STERLING RANCH SKETCH PLAN AMENDMENT

SKETCH PLAN AMENDMENT #3

STERLING RANCH SKETCH PLAN AMENDMENT

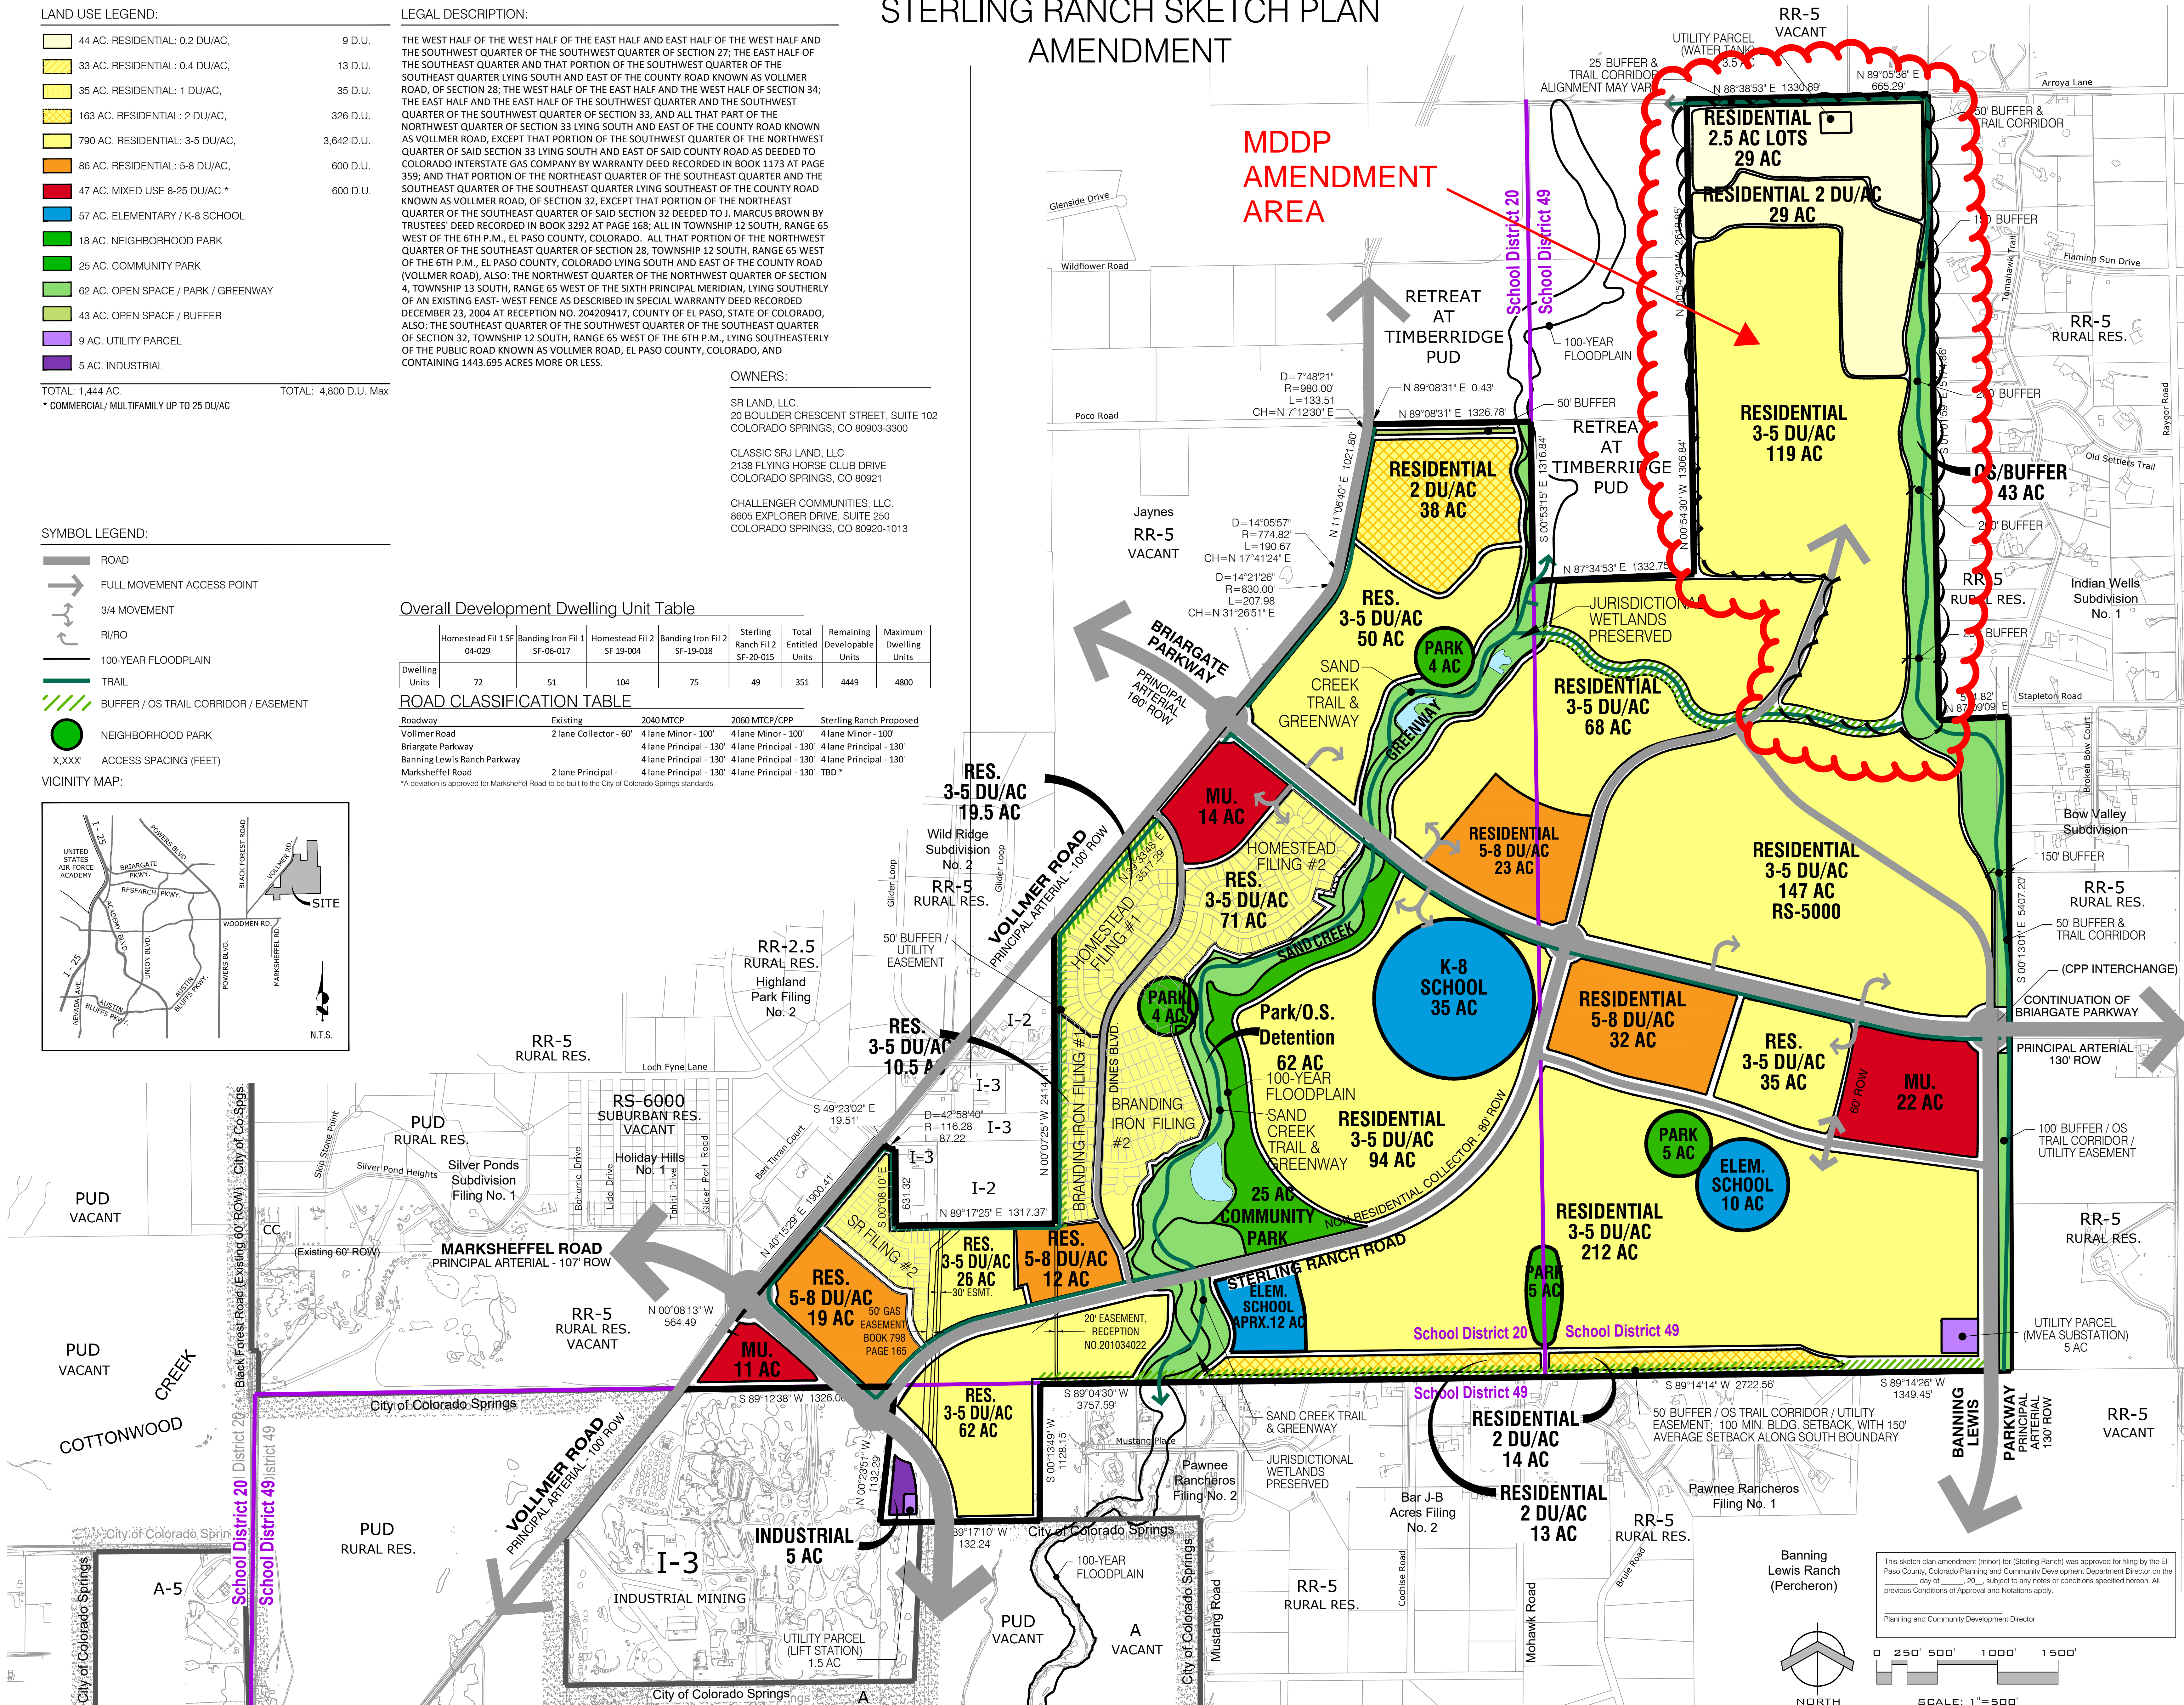
add amended area legal

Are these being amended? they have clouds they were not discussed in loi

Are these being amended? they have clouds they were not discussed in loi

Are these being amended? they have clouds they were not discussed in loi

NES: A LEGAL DESCRIPTION FOR A BUBBLE AREA WILL NOT BE ACCURATE. FUTURE ENTITLEMENT PLANS WILL SHOW THE CORRECT LEGAL BOUNDARY AND ACREAGE FOR THIS AREA.

NES: YES WE UPDATED SOME BUBBLES TO MATCH APPROVED/RECORDED PLANS FOR STERLING RANCH.
